# CITY OF ALBUQUERQUE

RE: **6212 Tesuque Dr NW**  
**Grading and Drainage Plan**  
**Engineer's Stamp Date: 8/24/18**  
**Drainage File: E10D049**

Based on the submittal received on 8/24/18, the grading and drainage plan cannot be approved until the following are corrected:

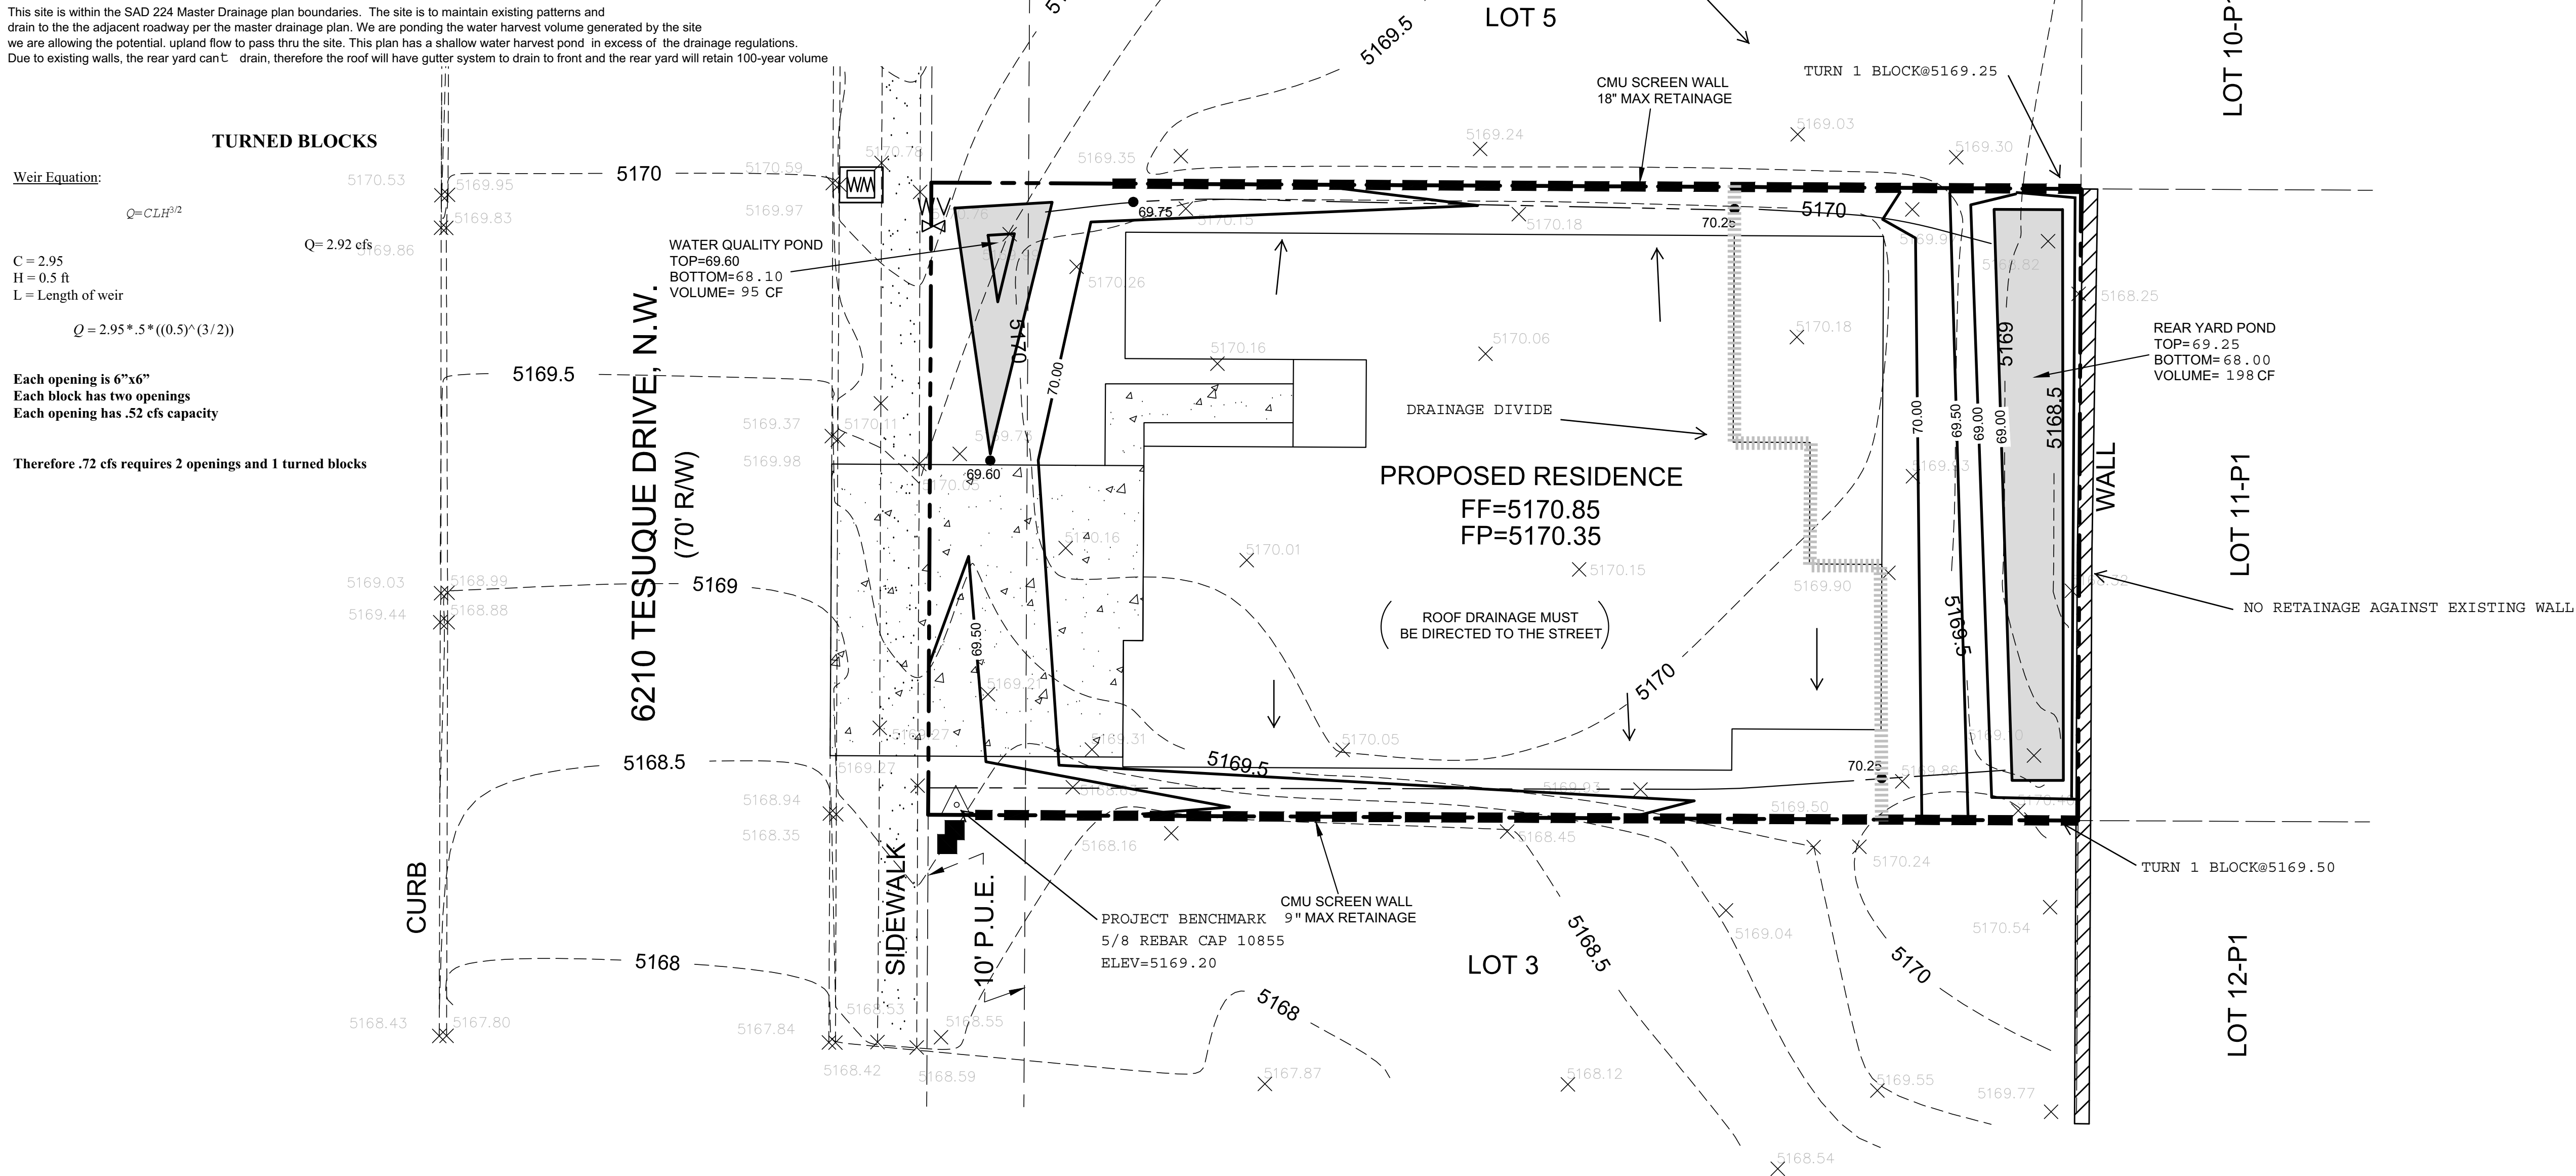
1. The narrative refers to SAD 221, but the site is not located in this SAD. The narrative and drainage assumptions need to be updated accordingly. The backyard ponding needs to be sized for the 100-yr volume for the area draining to it, but subbasins are not provided. Is it feasible to drain the entire roof area to the street? It seems as though some of it will need to be ponded in the backyard.
2. Provide wall sections through all perimeter walls showing footers, property lines, existing and proposed grades, horizontal and vertical dimensions. Demonstrate that grading and wall construction near the property line will not endanger adjacent property or constrain its use (DPM Ch.22, section 5 part B). Any private encroachment into neighboring private property will require written and signed permission from both property owners.
